## **FRITWELL PARISH COUNCIL (FPC)**

### **Response to Cala Development off Fewcott Road, Fritwell Application Reference: 21/02180/REM**

Typical Street Section - Secondary Road

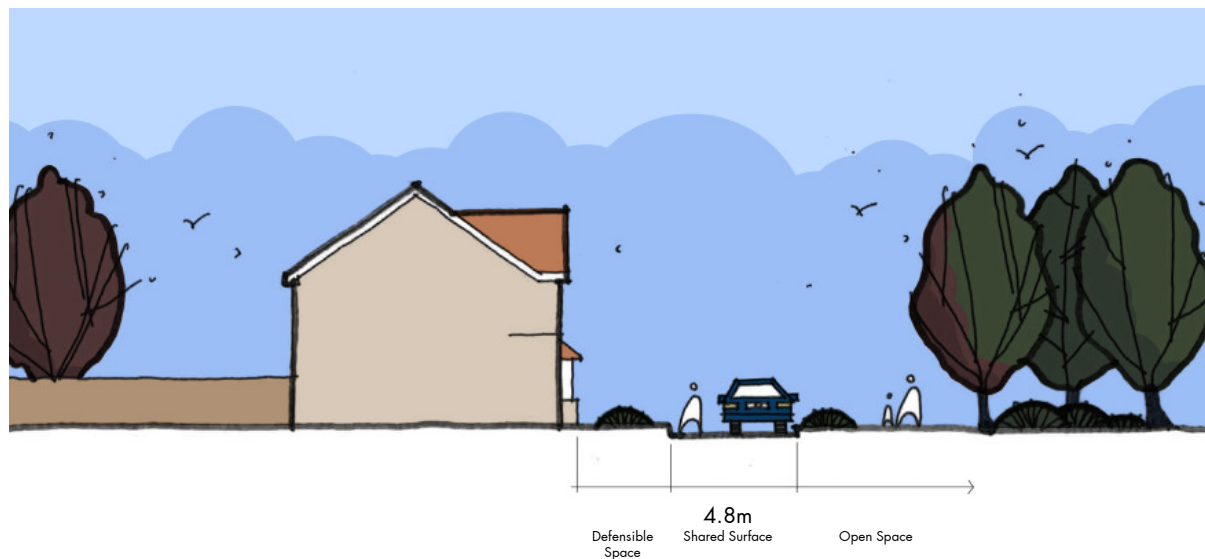
Footpath 219/6 is to be used to increase links from the new development to other parts of the village and is to be surfaced with permeable material. We suggest that Cala should consider a similar surface to the one used along

Church Lane (footpath 219/7). It is proposed to light this rural footpath and we request that this is subdued lighting at floor level to avoid light spillage onto the back of other homes and the adjacent farmland.

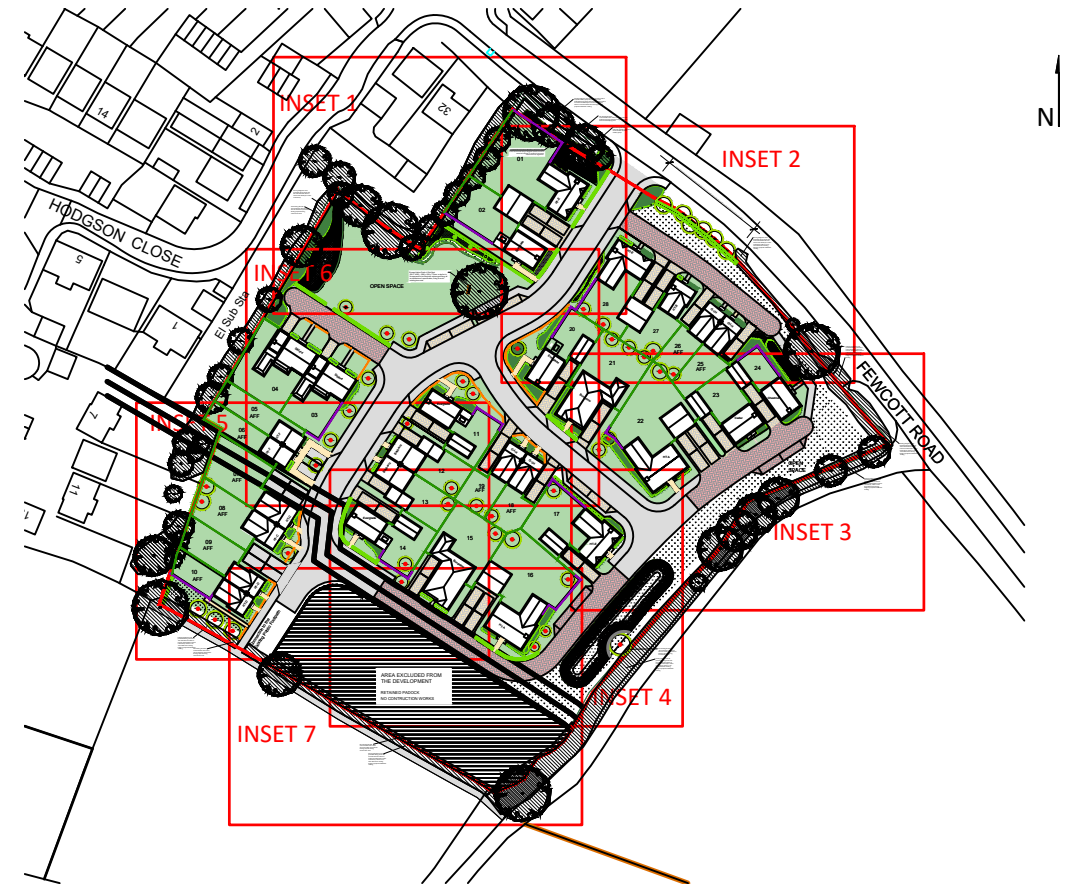
FPC strongly recommends that the building materials used for this development are consistent with neighbouring developments (Fewcott View, Covert Farm and Hodgson Close). Brick built or partially brick built properties are inconsistent with many properties in the village. FPC would also like the planting plan to be of native species where feasible.
